Planning Application Ref: Y/72/20/RES

Location: Land at Stakers Farm, North End Road, Yapton

Description of works: **Approval of reserved matters following outline approval Y/44/17/OUT for the erection of 70 No. dwellings, public open space, play area, drainage & landscaping. This application affects the character & appearance of the Main Road/Church Road Yapton Conservation Area & affects the setting of Listed Buildings**

INFILTRATION BASIN WITH INFILTRATION BLANKET BENEATH

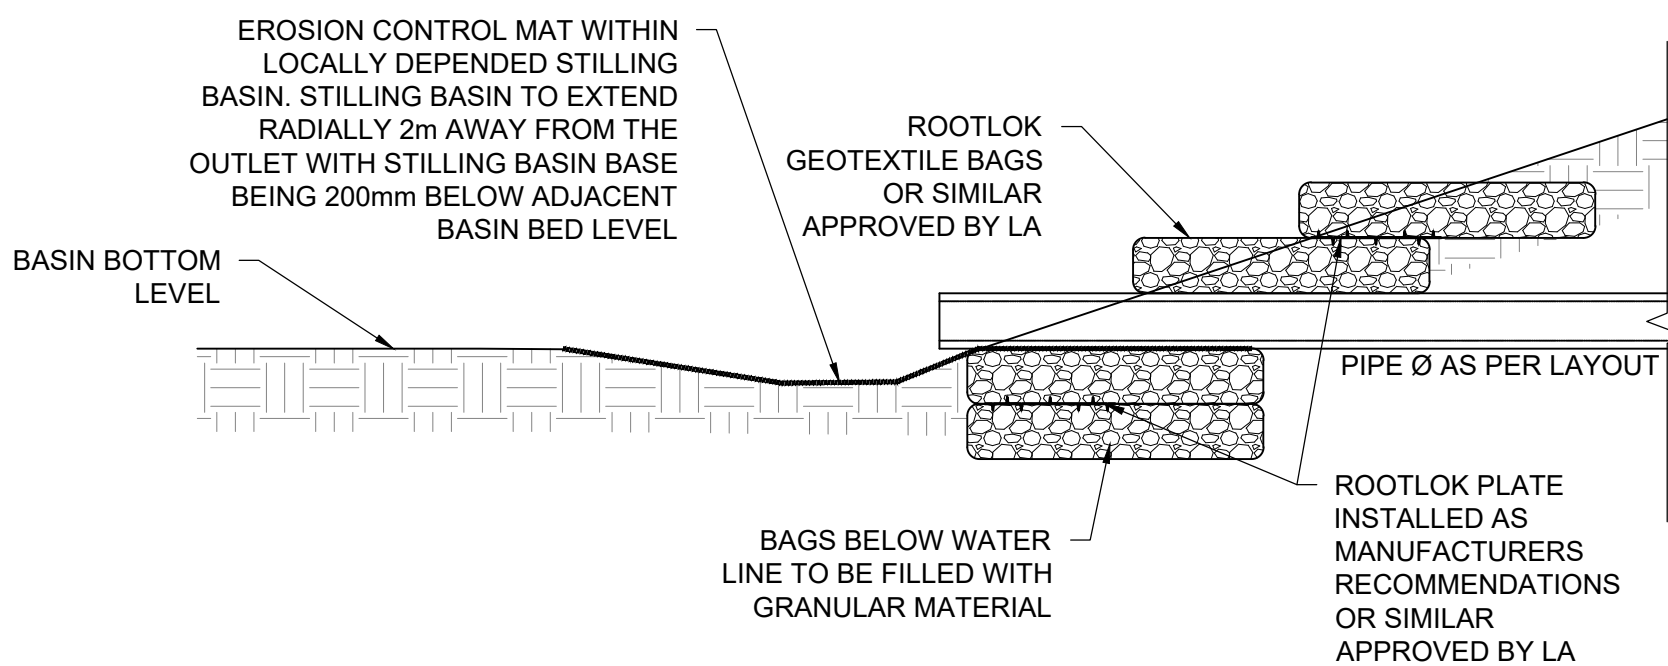
- The excavation into the RPA of T21 (and removal of T20) to accommodate the Infiltration Basin is undesirable from an arboricultural perspective and may also be unacceptable to our Drainage Engineer given growth potential of the former.
